# 2.0 Phase 2 integration with Phase 1

# APPENDIX A PART 2 OF 3

# 3.0 General Teaching Spaces

- CHANGES**
- ① RECONFIGURATION OF VERTICAL CIRCULATION
 - ② GENERAL TEACHING SPACE MOVED OFF FACADE TO FURTHER PROVIDE ACTIVATED SPACE ALONG BROADWAY AND JONES STREET
 - A PHASE 1 & 2 ADJUSTMENT
 - POSITION OF BROADWAY FACADE MOVED TO BOUNDARY
 - PROVISION OF ACTIVATED SPACE ALONG BROADWAY FACADE

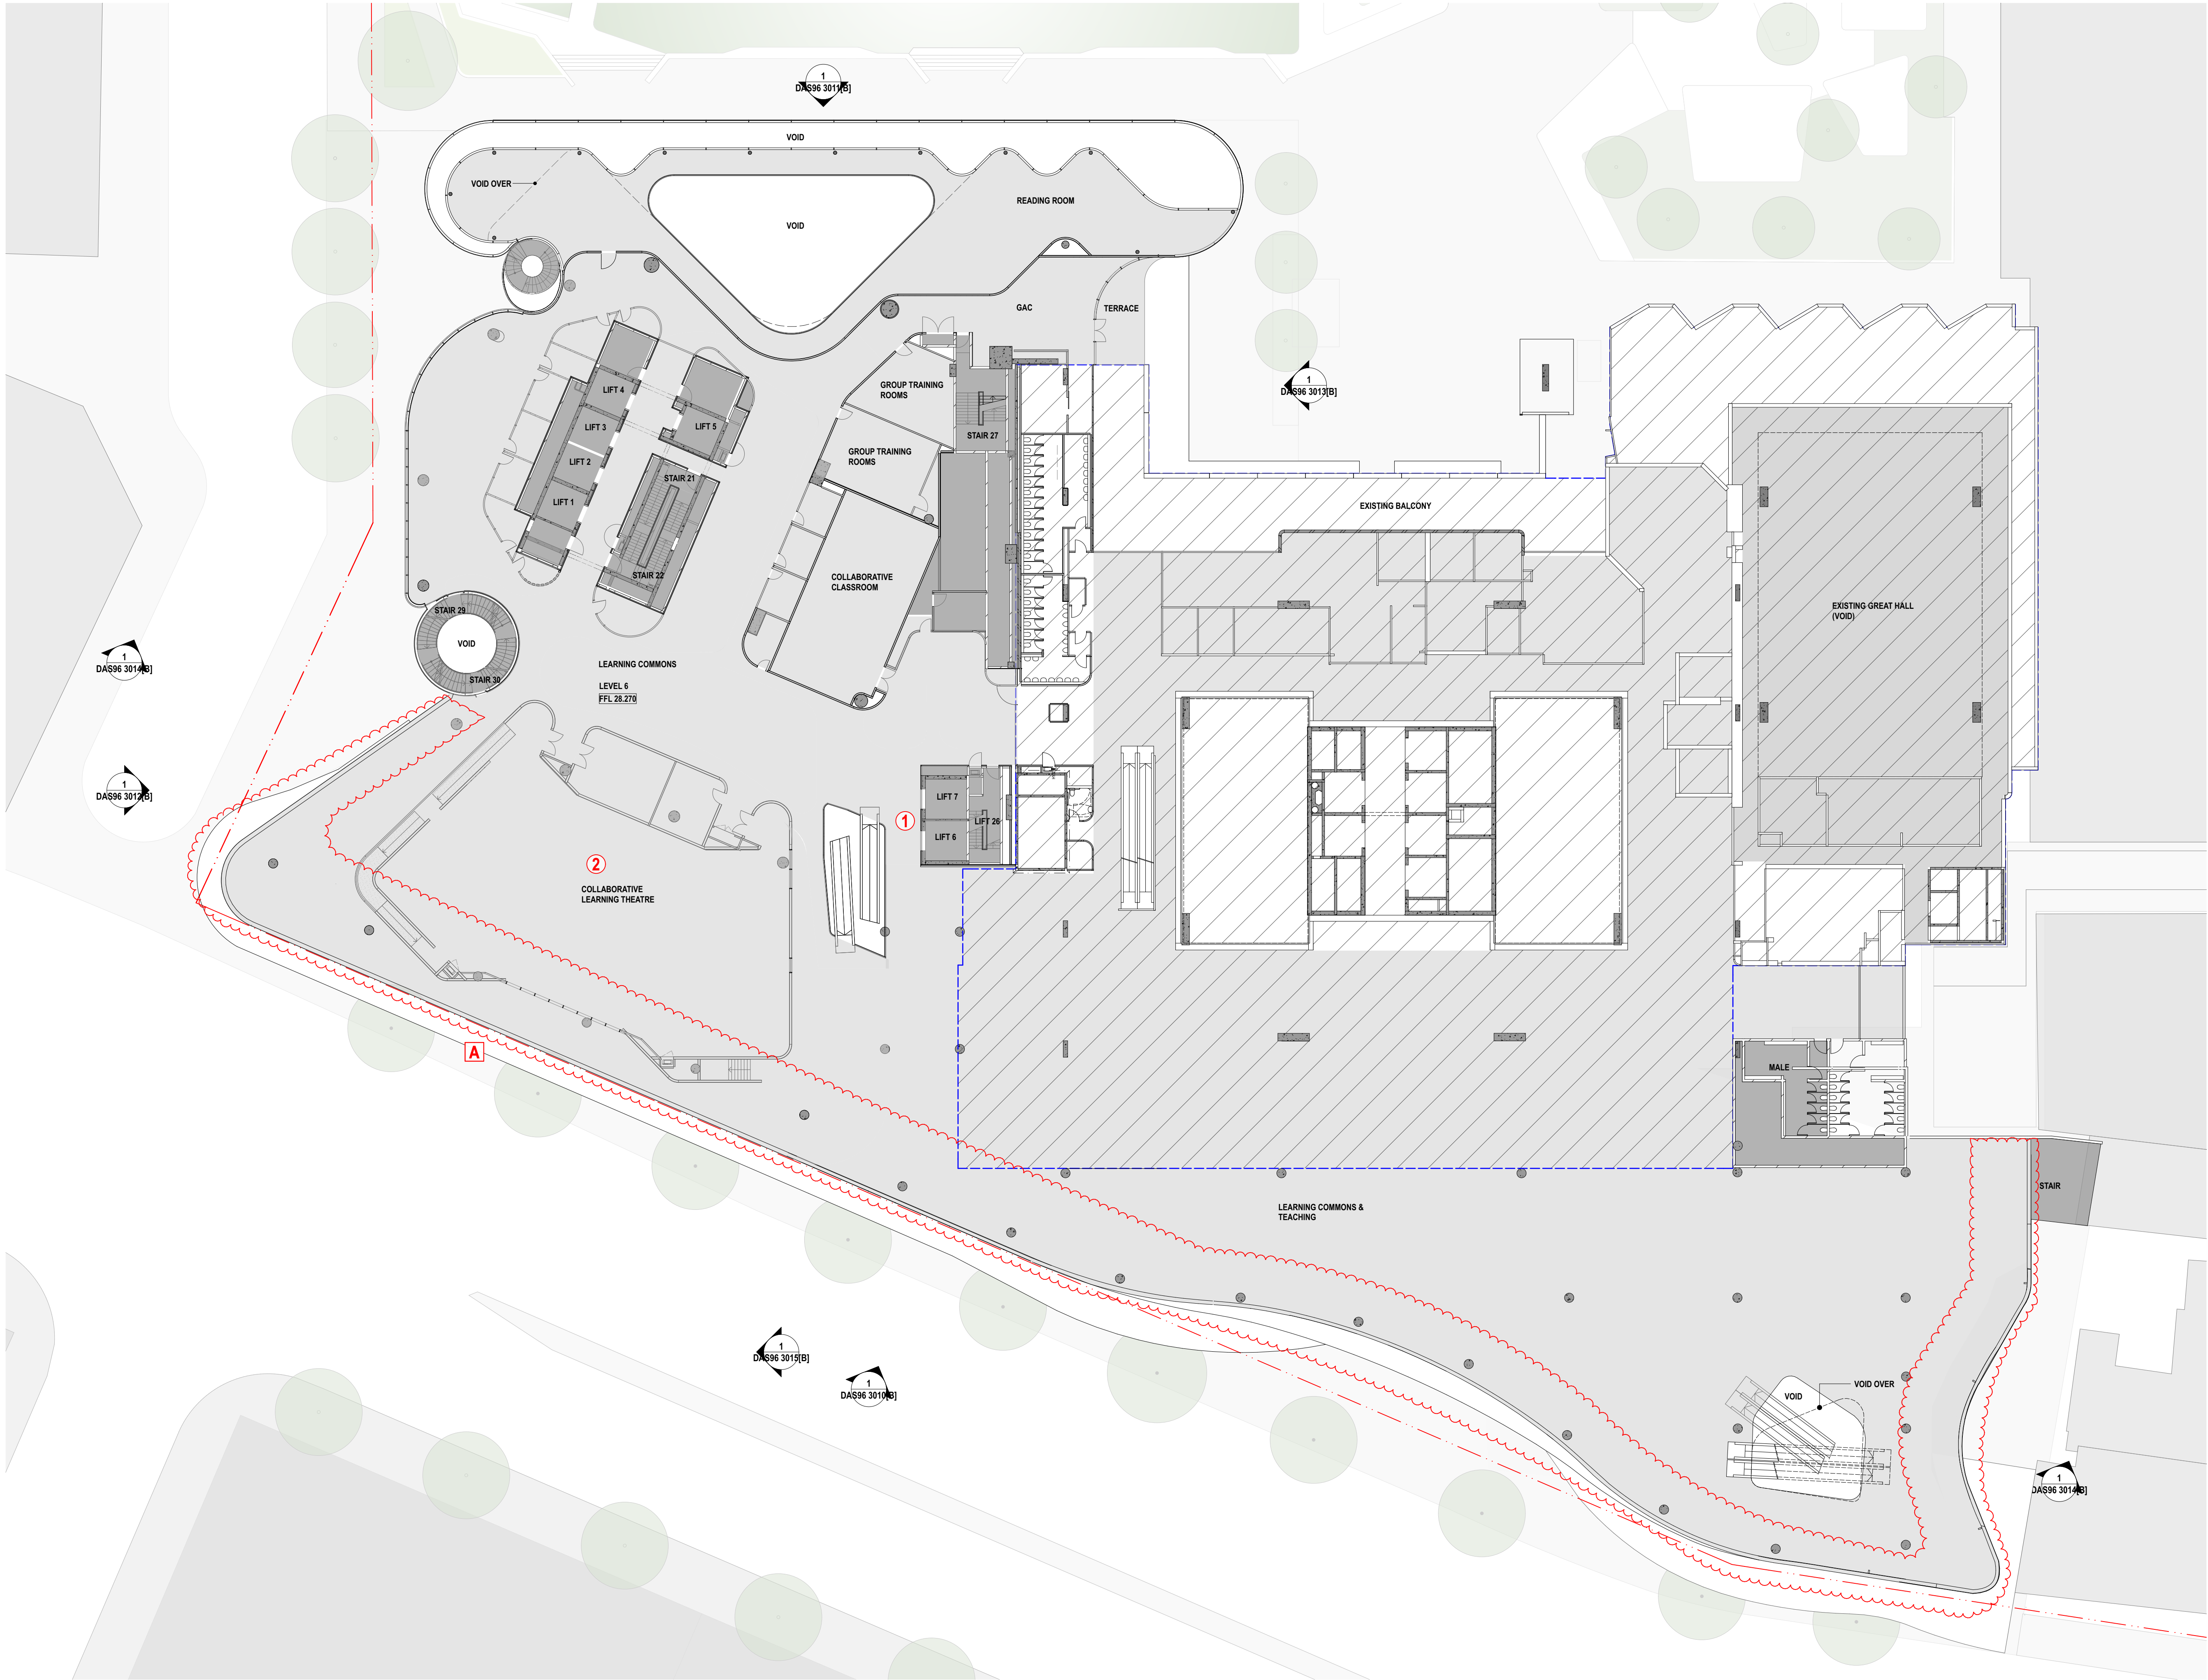
Clarification should be provided in relation to conflicting information regarding the Collaborative Learning Theatre, which appears to have been replaced by three single storey General Teaching Spaces. Further justification and detail is required to support this modification, including ceiling heights, program, entry and circulation and capacity.

In the DA three collaborative teaching spaces were shown on levels 5, 6 and 7. These spaces have been retained in the Section 96 submission. The only change that has occurred is the shape of these spaces as a result of adjusting their position to be more central on the floor plate and away from the facades on Broadway and Jones Street. The spaces shown in the Section 96 retain the same proposed ceiling heights, programme, circulation and capacity.

The smaller 200 GTS on level 7 has been relocated to the Broadway facade to occupy the same location of the larger 350 GTS on levels 5 and 6, however is a smaller teaching space.

The adjusted location of each of the GTS provides a much improved relationship with the Broadway facade allowing informal learning spaces to be located between the GTS and the facade.
